Application for Removal or Variation of a Condition following Grant of Planning Permission or Listed Building Consent

Elmbridge Close

Erection of single storey rear/side extensions to include extension of roof following alteration/demolition of existing extensions and conversion of roof space to habitable use to include rear dormer with Juliet balcony, 1 front roof light and 3 side roof lights. Erection of boundary fence (revised description and plans)

27982/APP/2023/3260

Drawing Number
230046-PI -D 0010 A

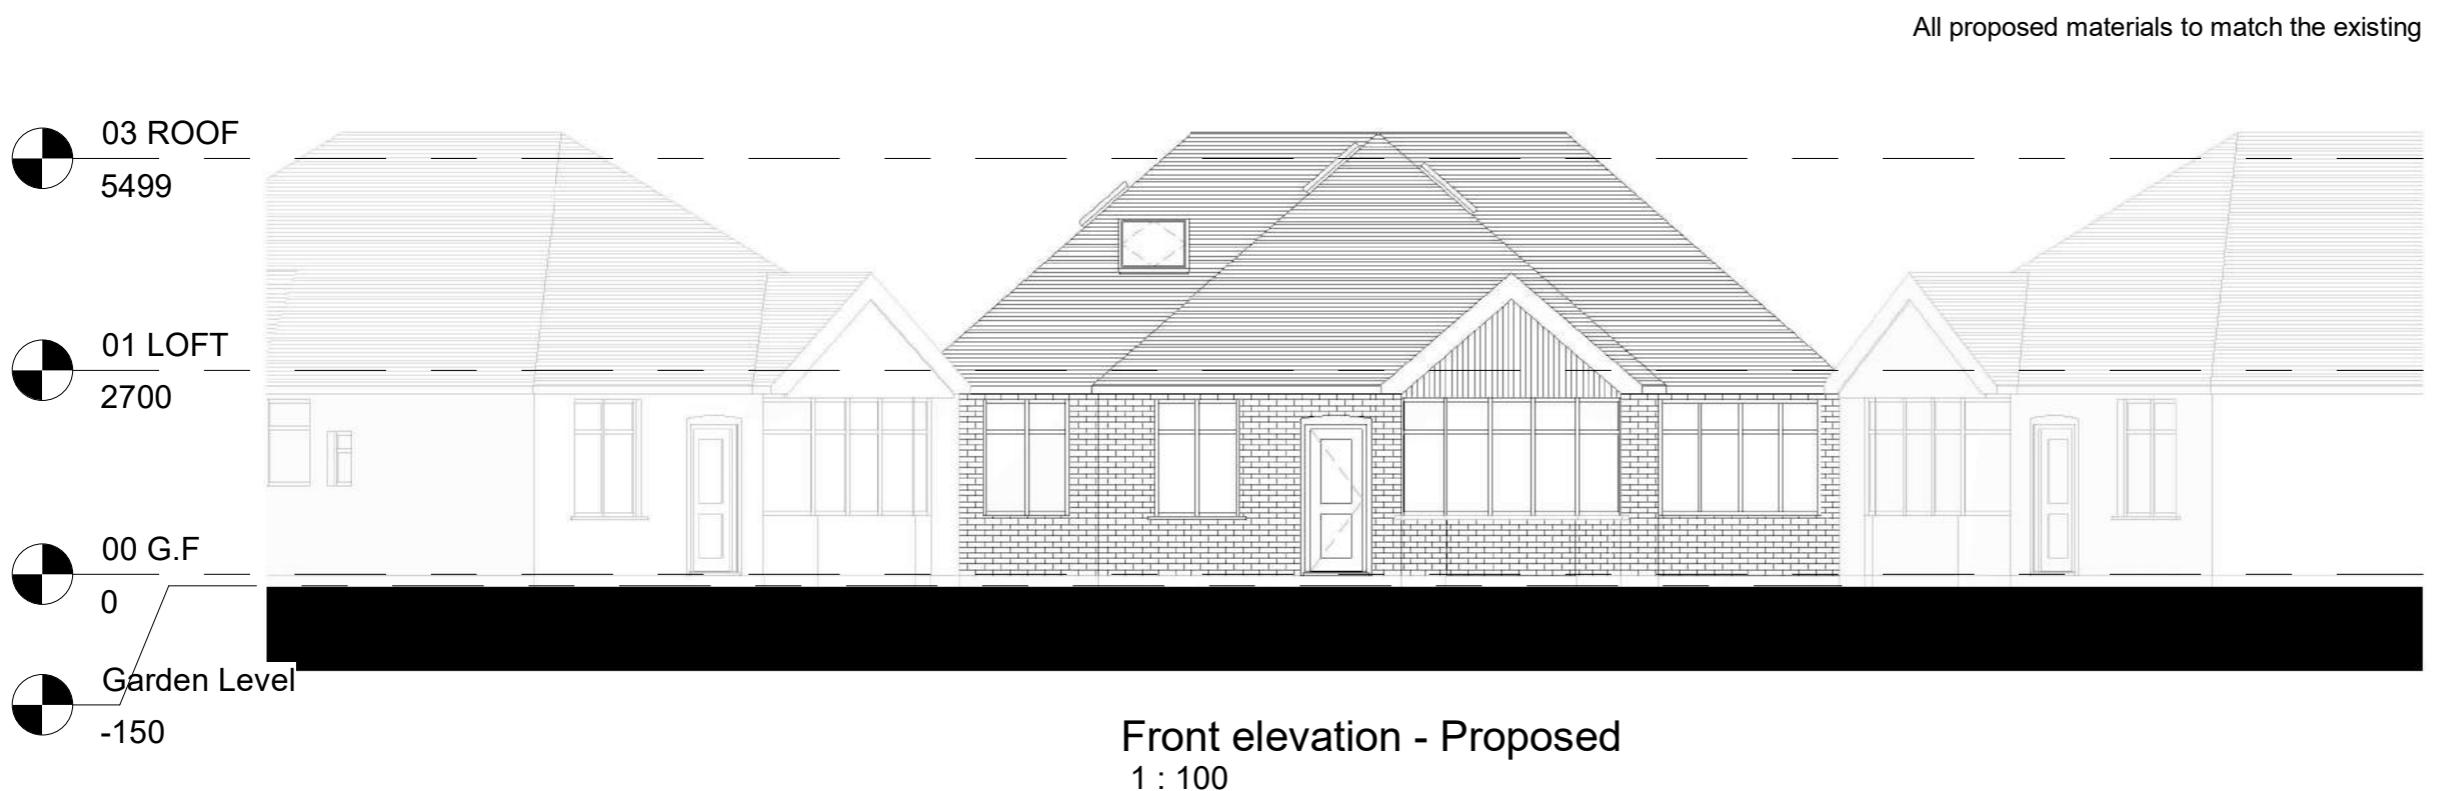
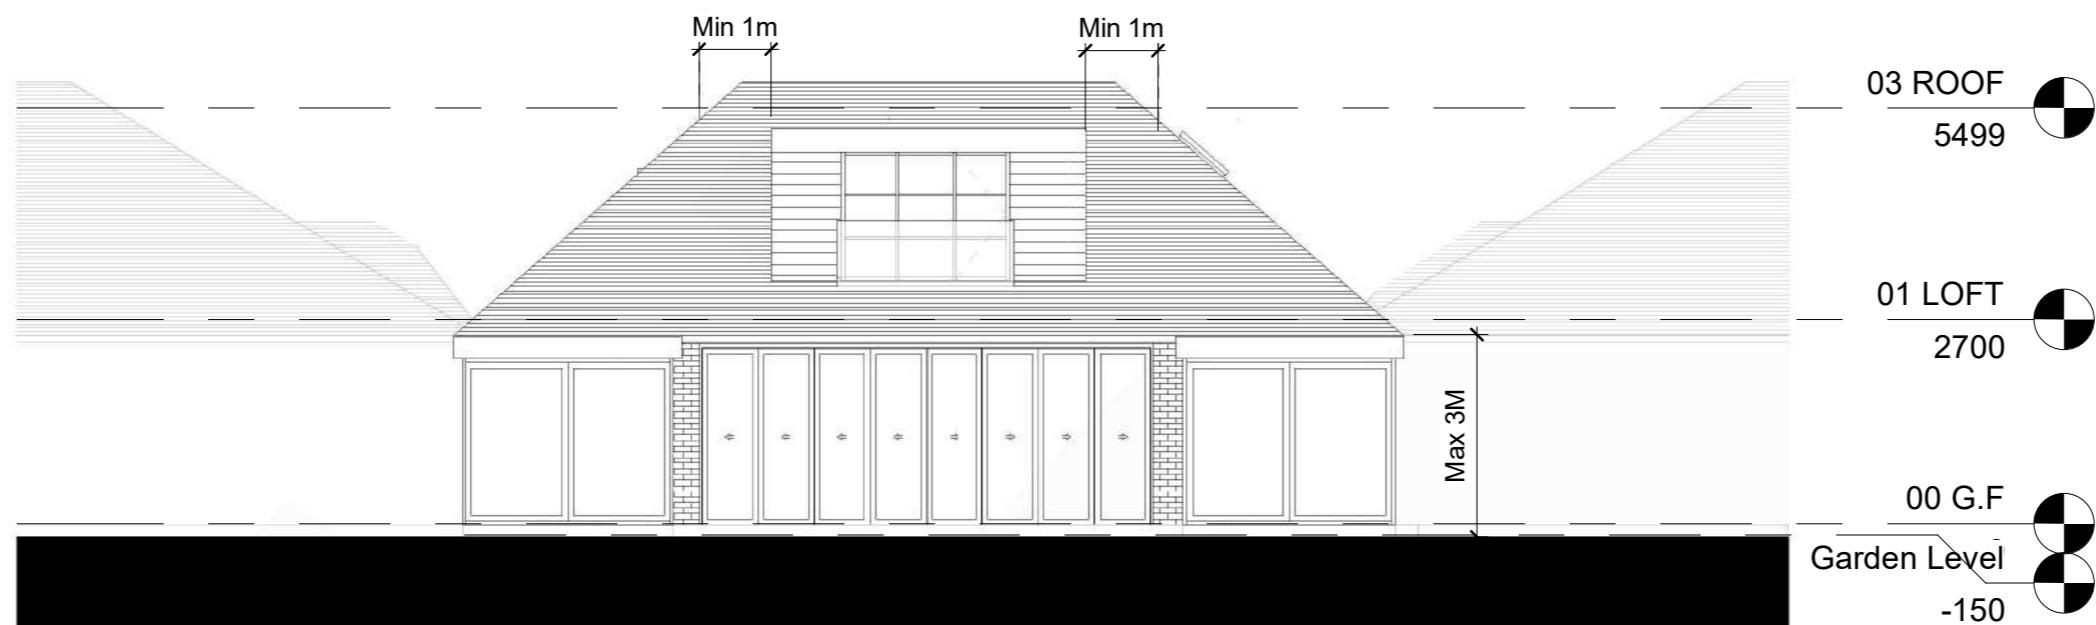
To decrease the area of glazing on the rear and two flank elevations and to replace these areas with brick walls to match the existing.

The approved drawings are to be replaced with the following P3 revision drawings:

230046-PL-D 0001A
230046-PL-D 0003A
230046-PL-D 0004A
230046-PL-D 0005A
230046-PL-D 0006A
230046-PL-D 0007A
230046-PL-D 0009A
230046-PL-D 00010A
230046-PL-D 00011A
230046-PL-D 00012A
